Tillbridge Solar Project (EN010142) - Summary of Written Representations.

Watercourses, Flood Zones and Internal Drainage Boards (Sheet 1 of 3)

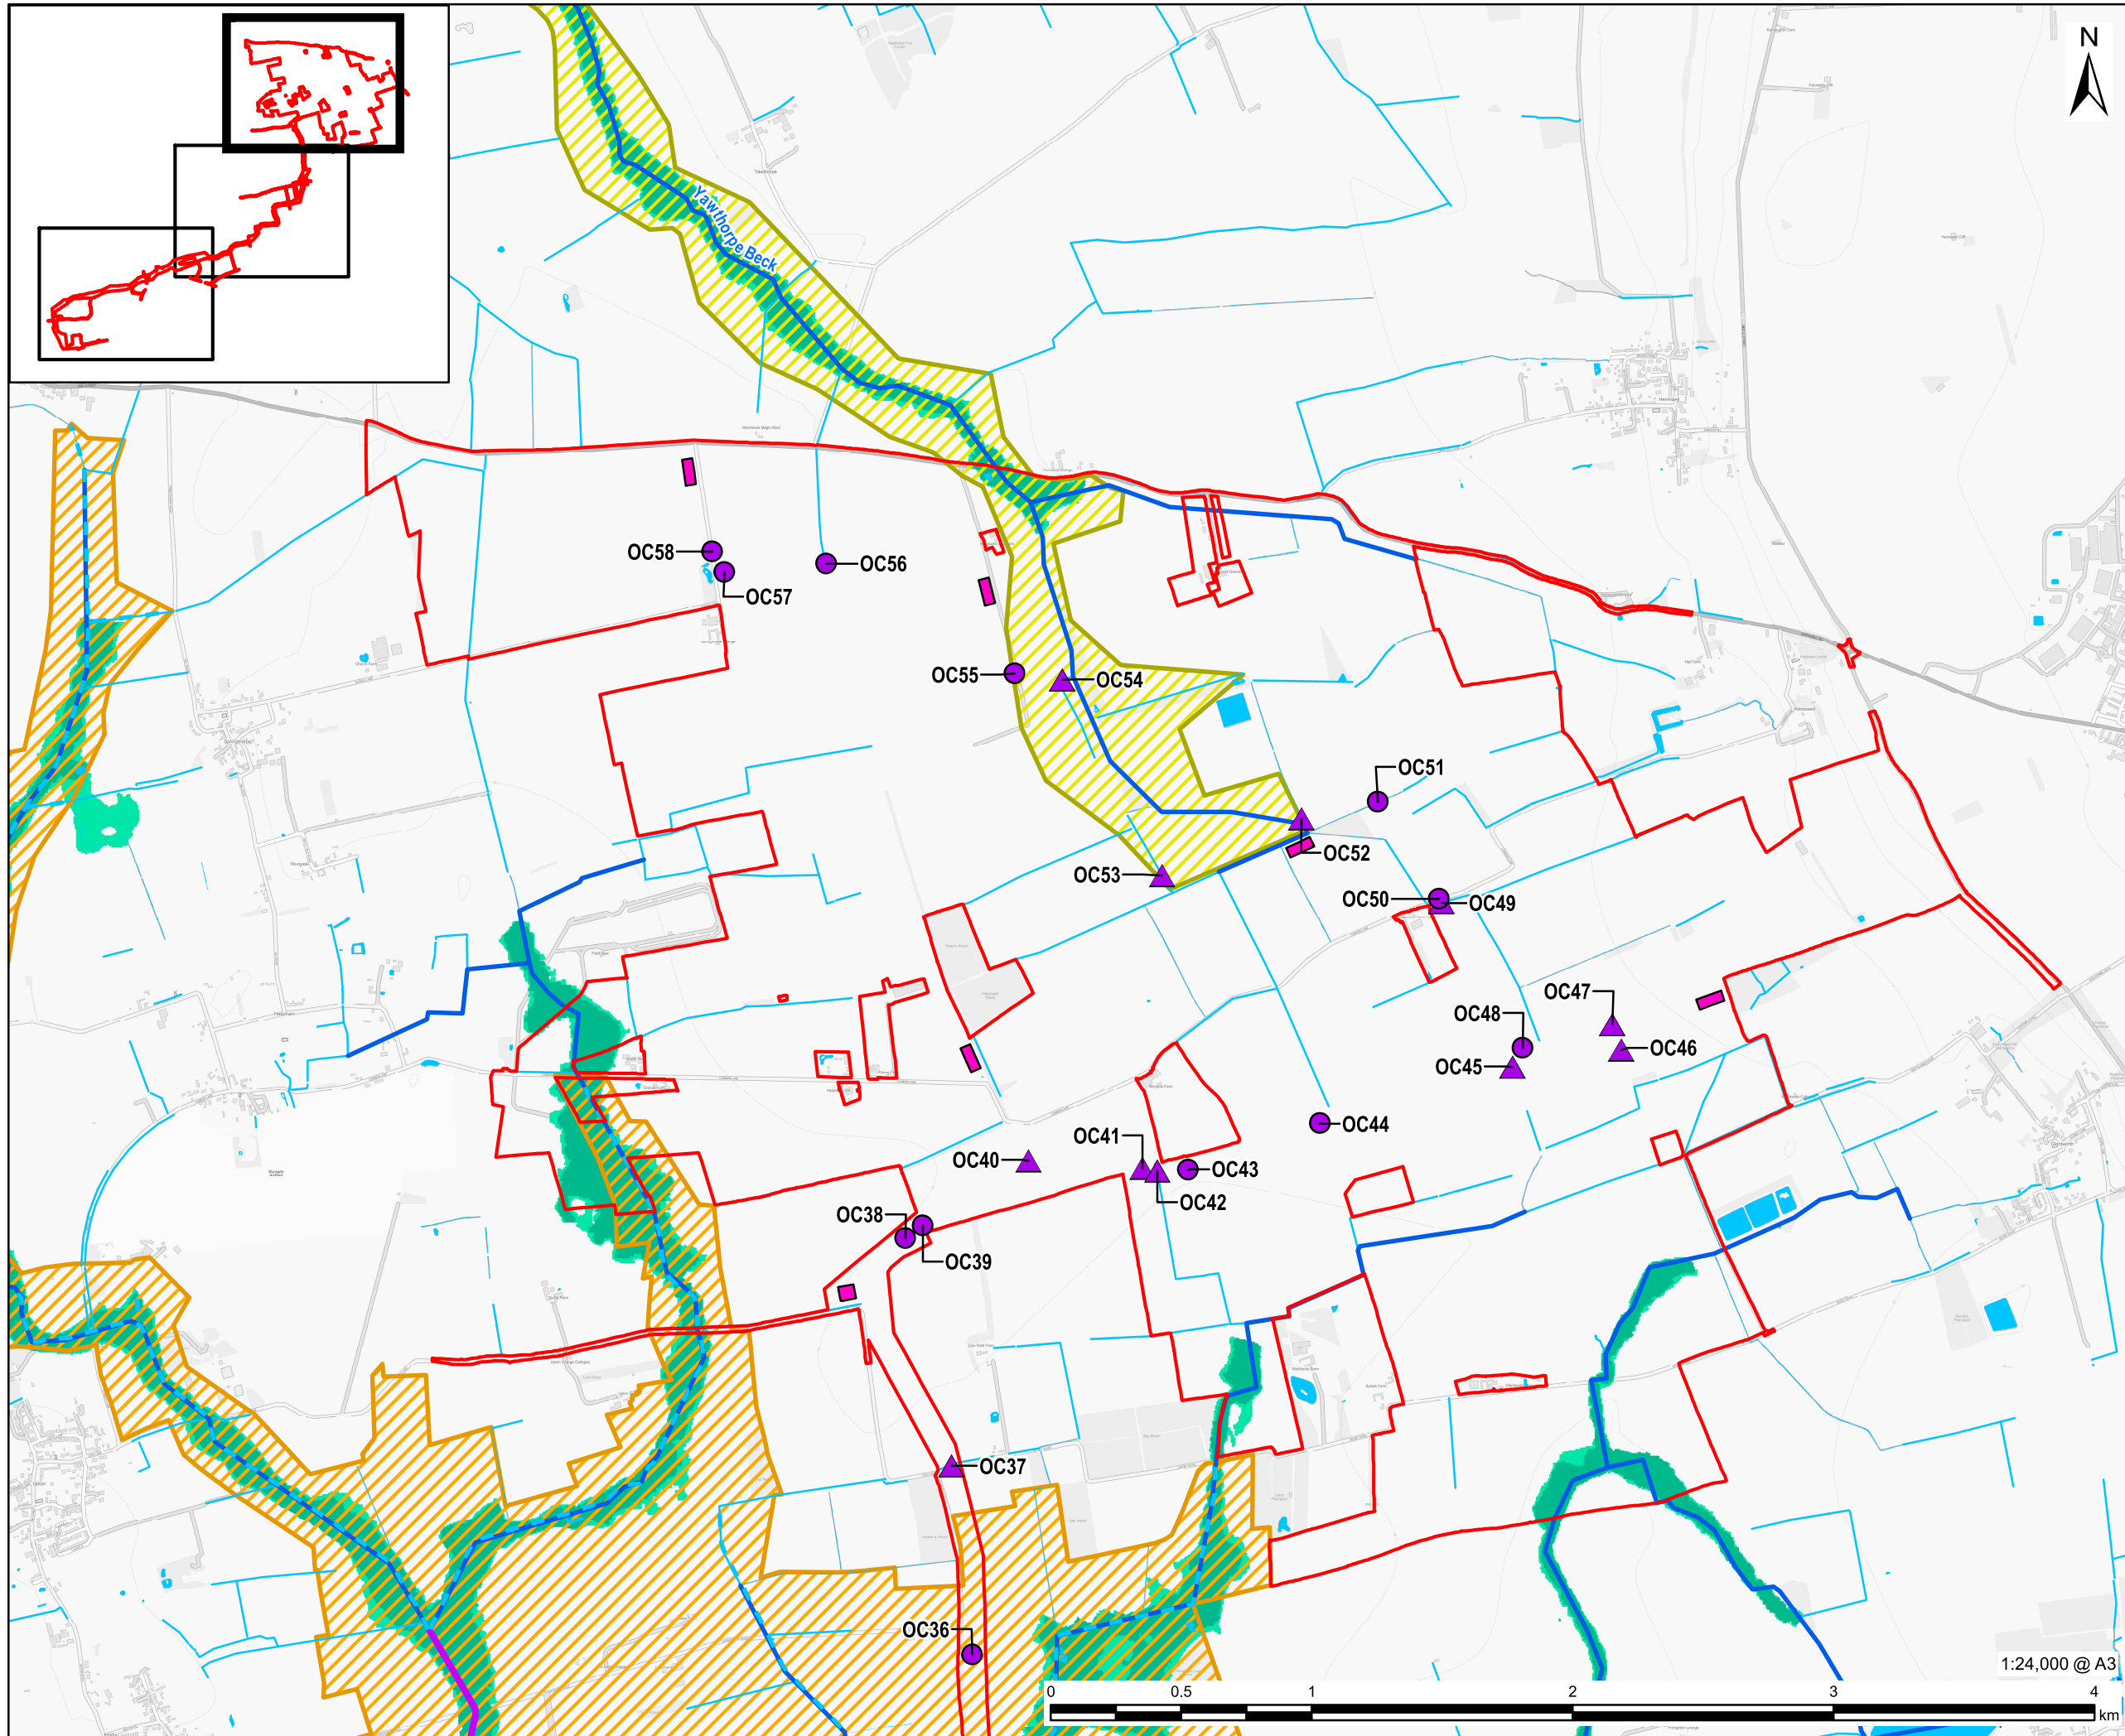
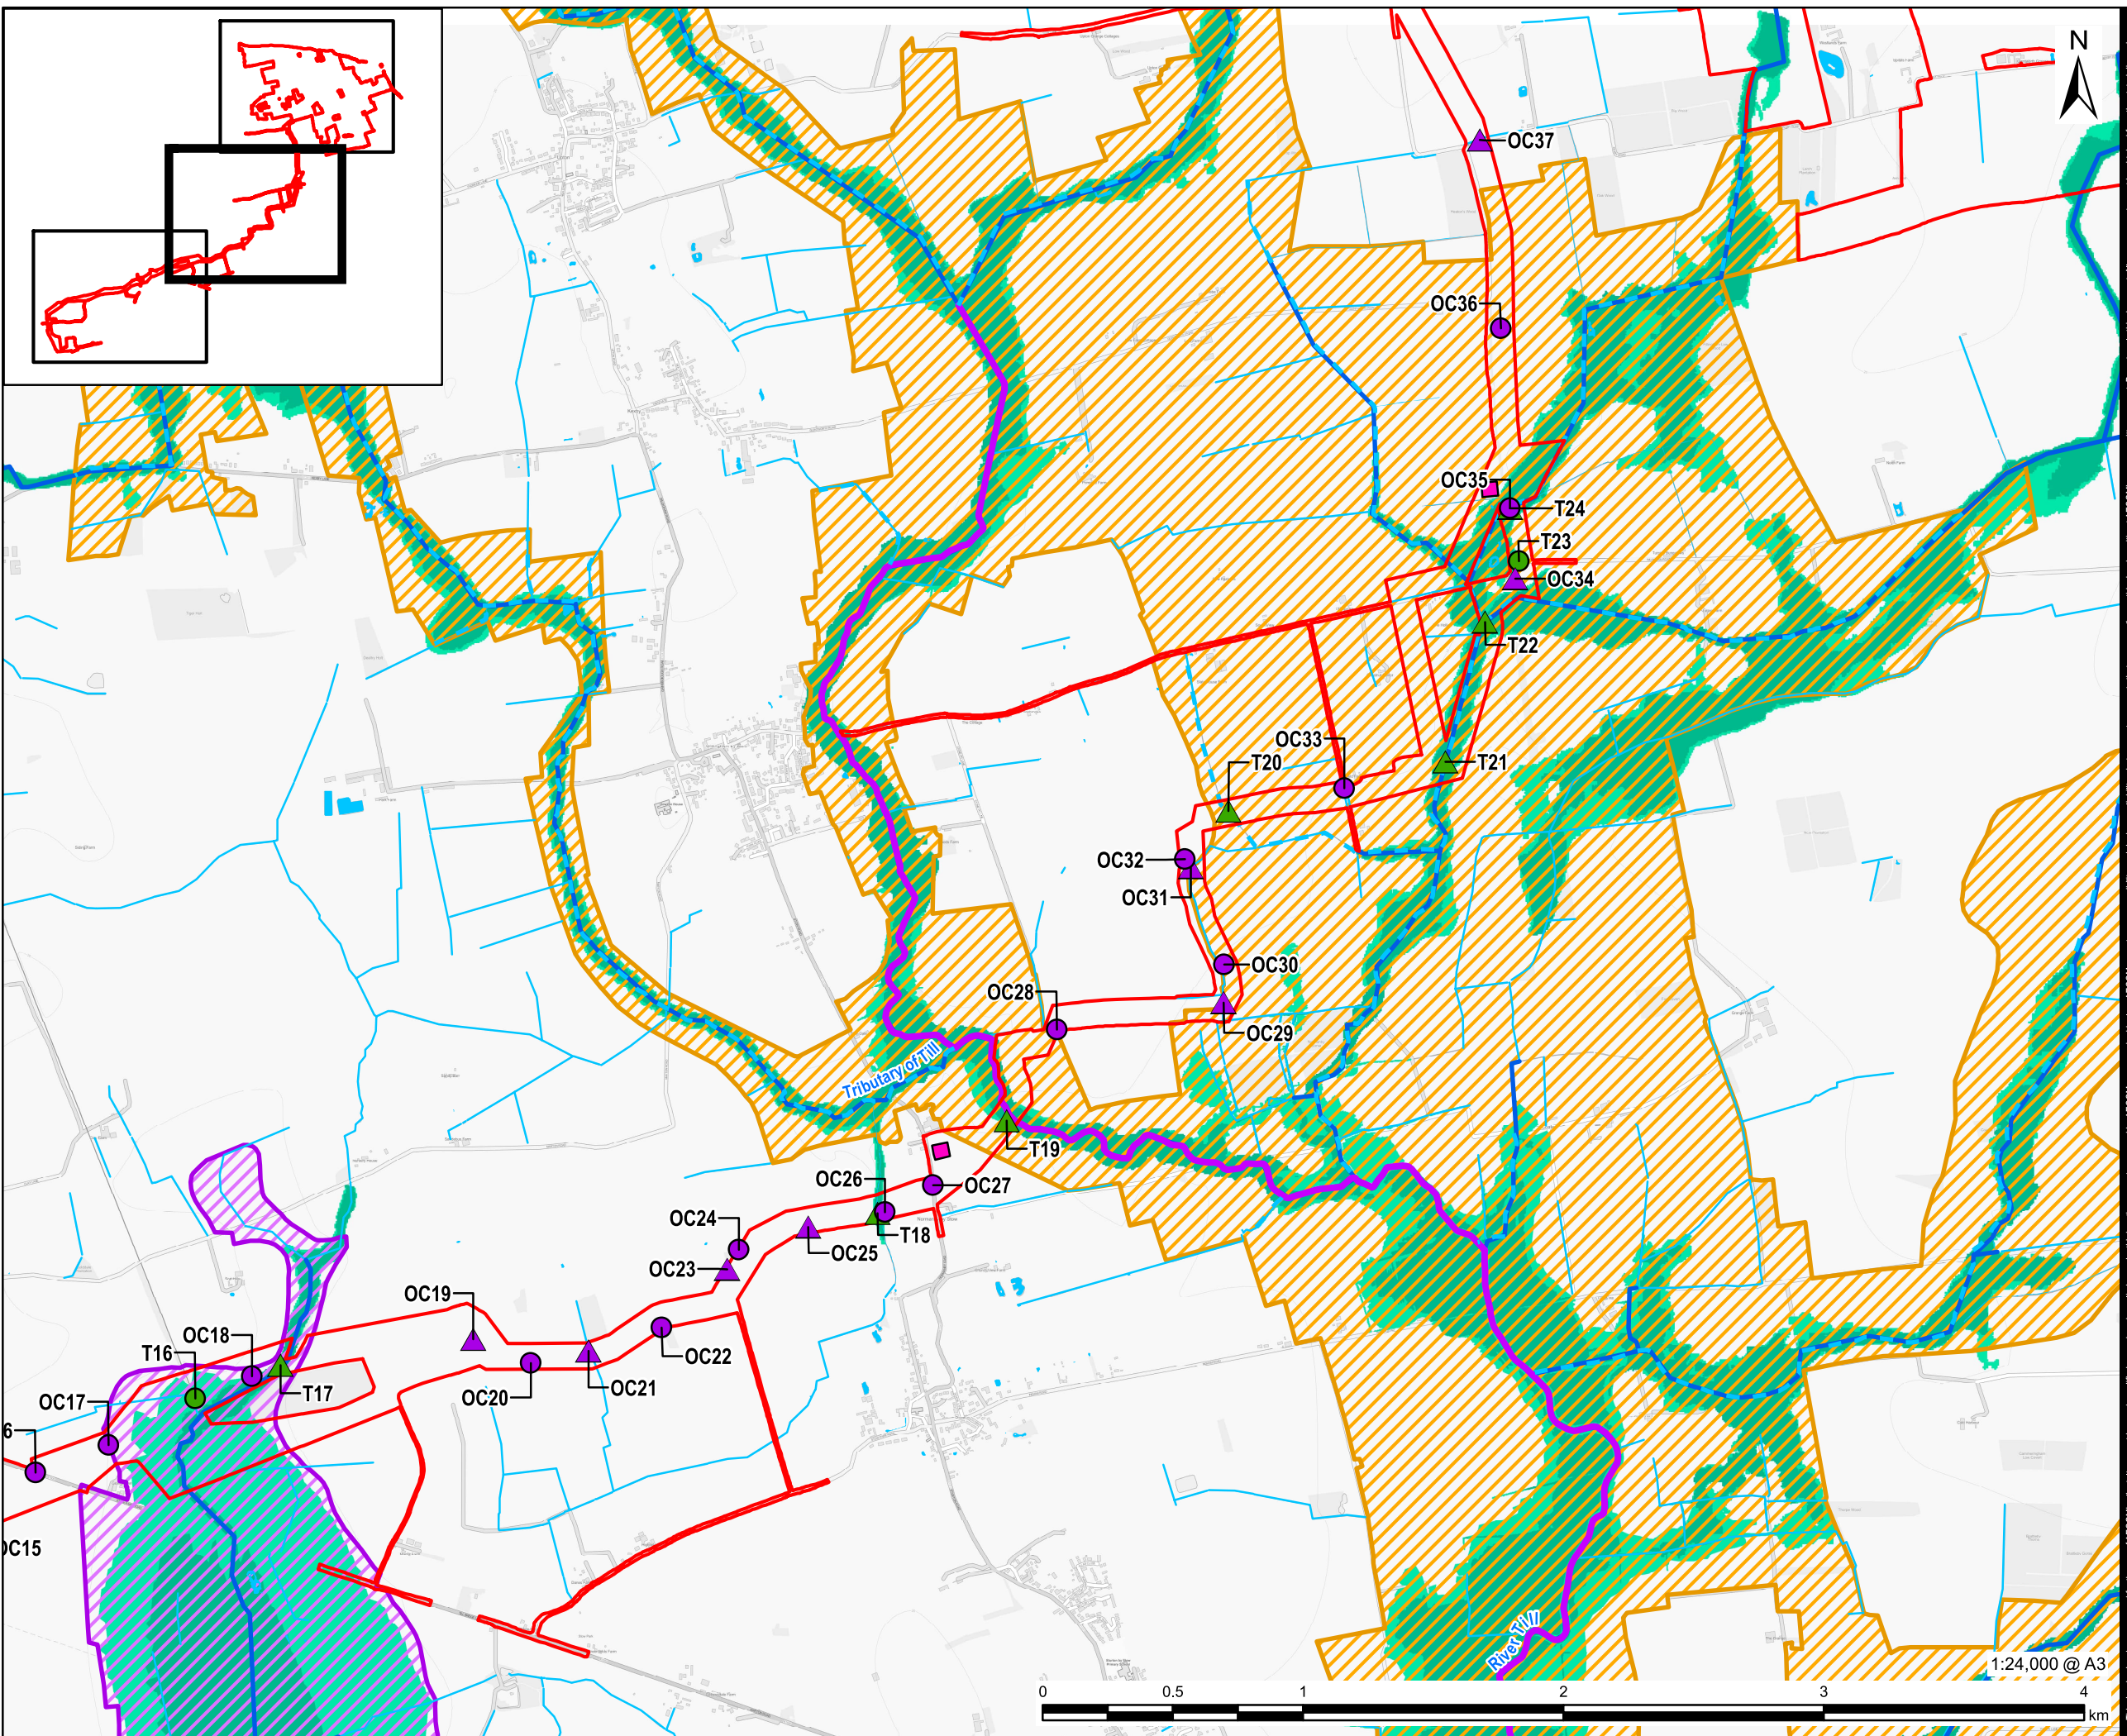
- 2.1 We wish to be a named consultee on the CEMP (and that this enables us to have further opportunities to comment on the emergency response plan and river crossing proposals) and the decommissioning and restoration plan.
- 2.2 On receipt of information in relation to 2 temporary compounds within Flood Zone 3, we are happy subject to a Condition being included in the DCO to secure a safe refuge within them and various items in the emergency response plan.
- 2.3 Section 8.1.2 of the Flood Risk Assessment needs amending to take account of the findings in relation to the temporary compounds.
